City of Albuquerque

September 20, 1995

RE: DOWNTOWN DAYCARE (J14/D111) DRAINAGE AND GRADING PLAN
SUBMITTAL FOR BUILDING PERMIT AND SO-19 APPROVAL.
ENGINEER'S STAMP DATED 8-15-95.

GRADING AND DRAINAGE PLAN DOWNTOWN DAYCARE

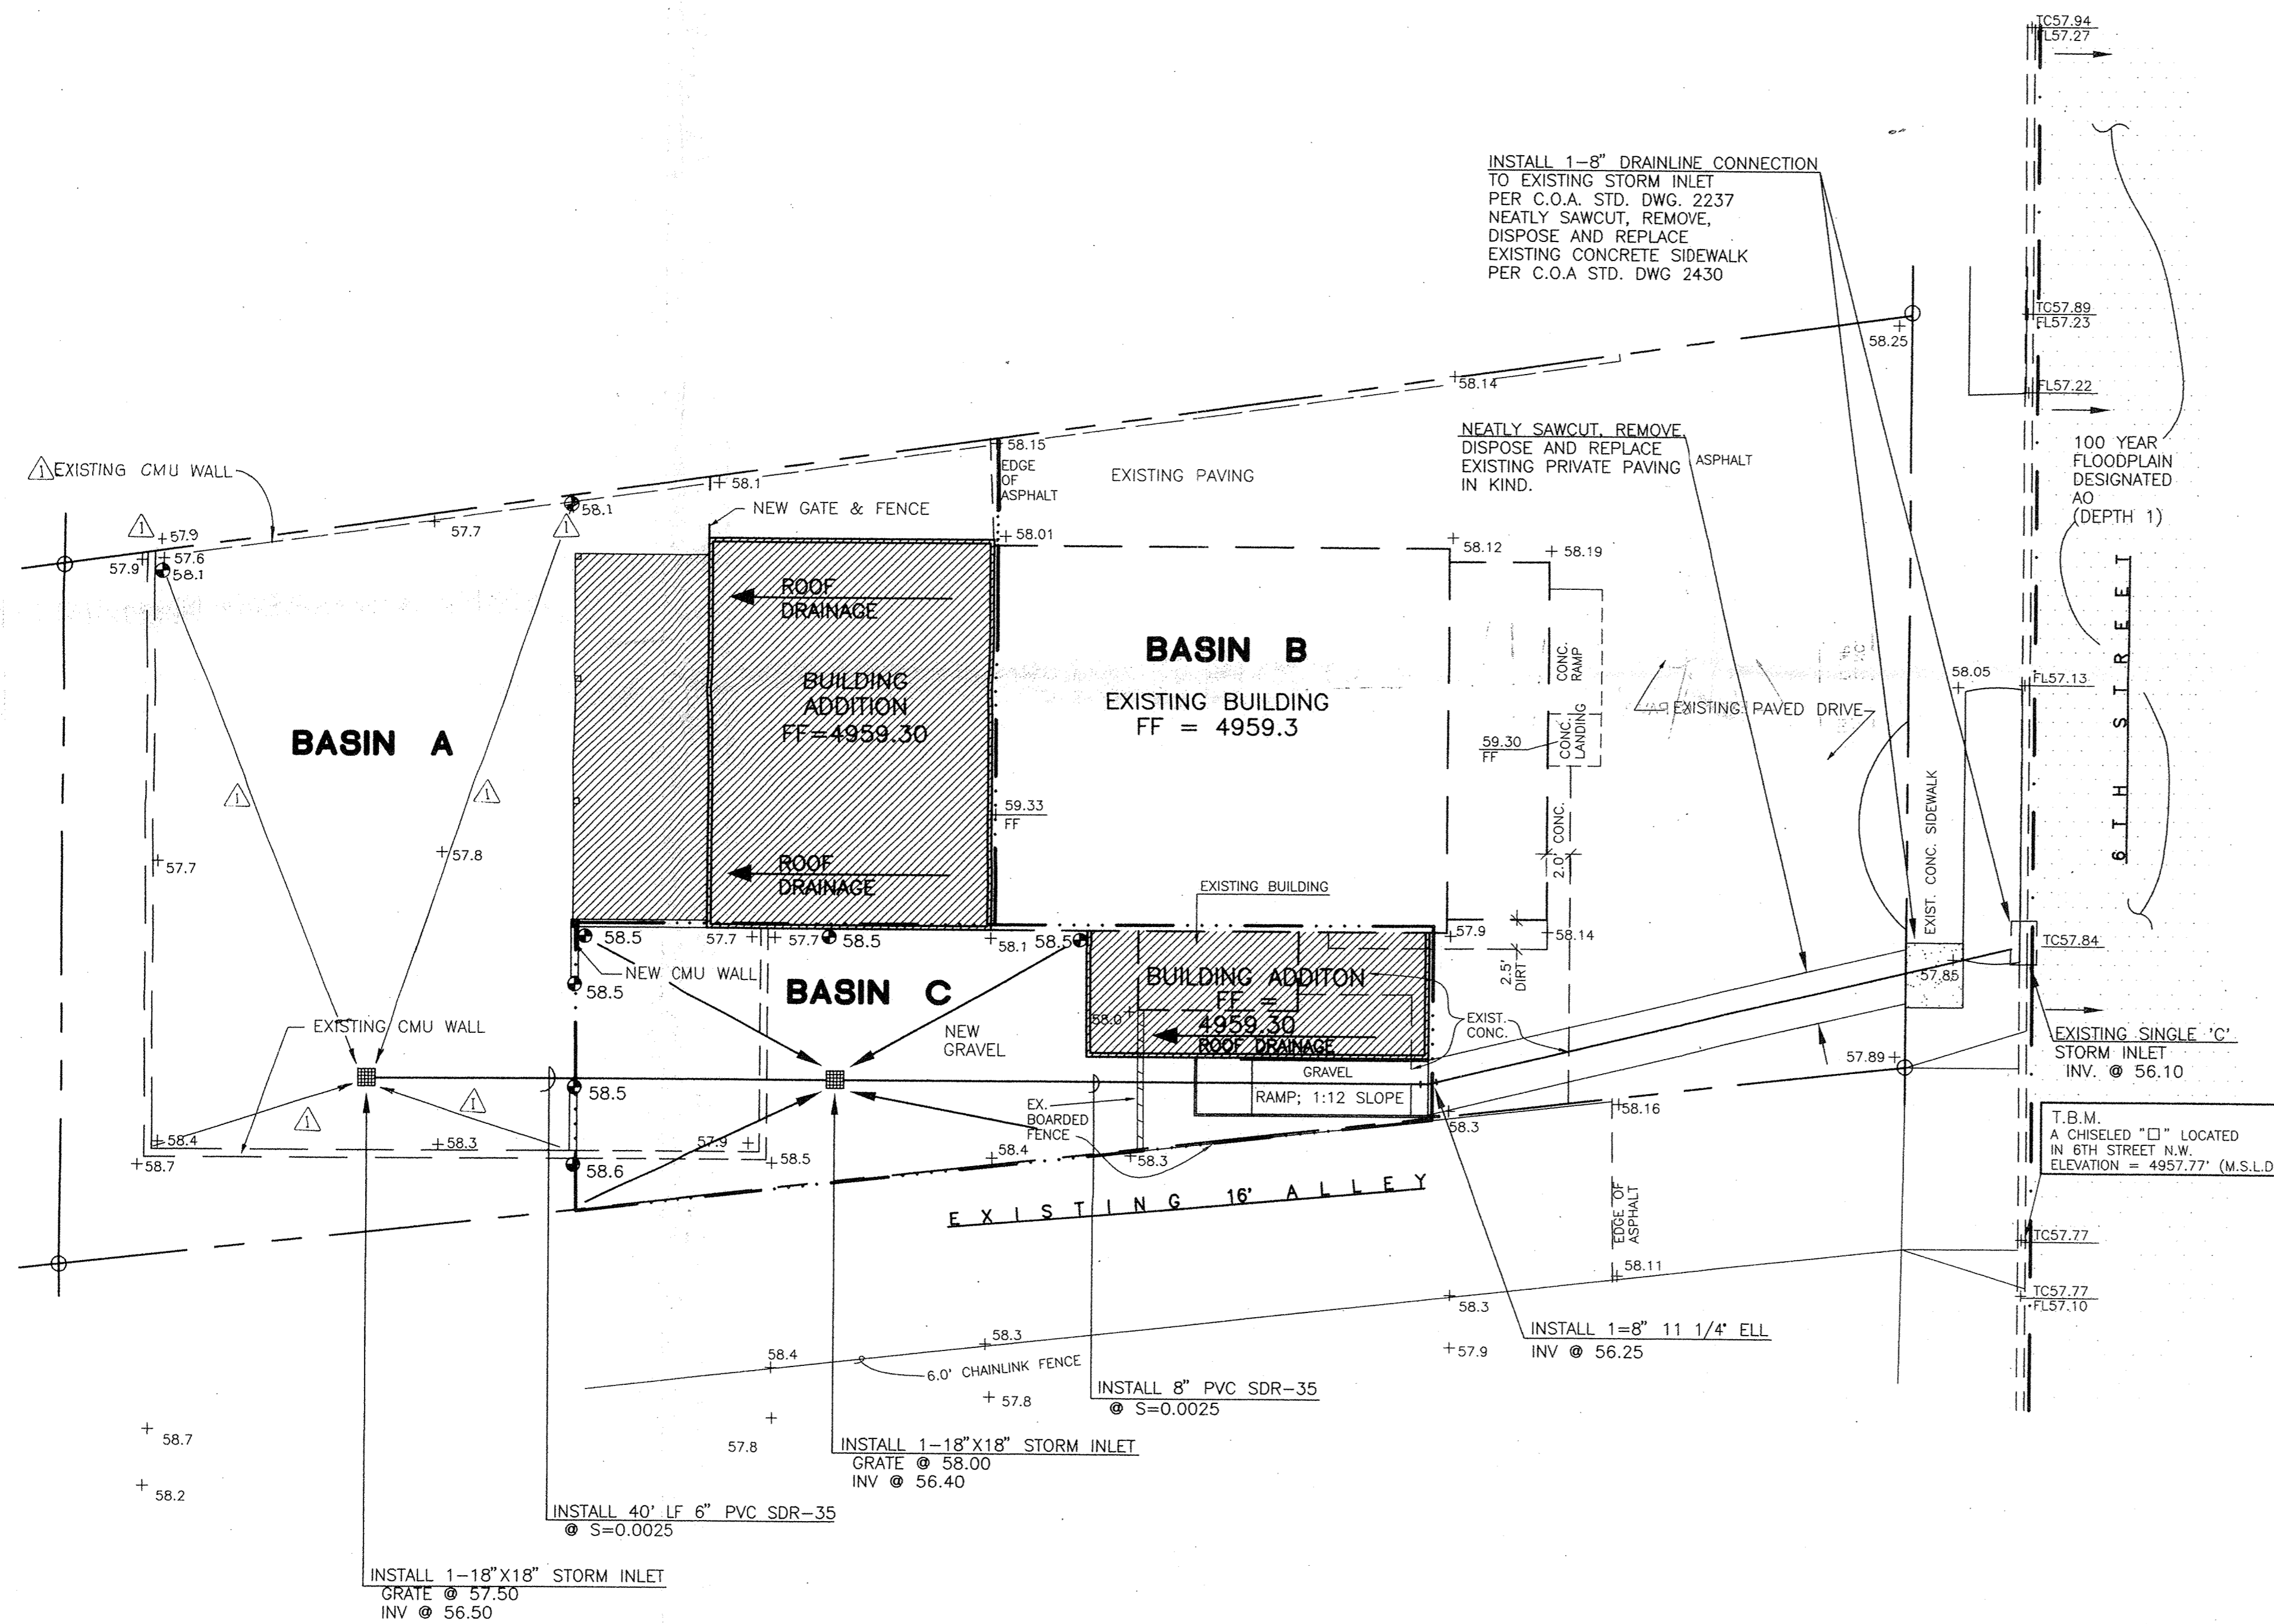
As stated in my previous letter, dated 8-4-95, it is the owner's responsibility to maintain the storm drain system. I recommend the use of cleanouts in the storm drain line to avoid expensive repairs, if the pipe becomes blocked or clogged.
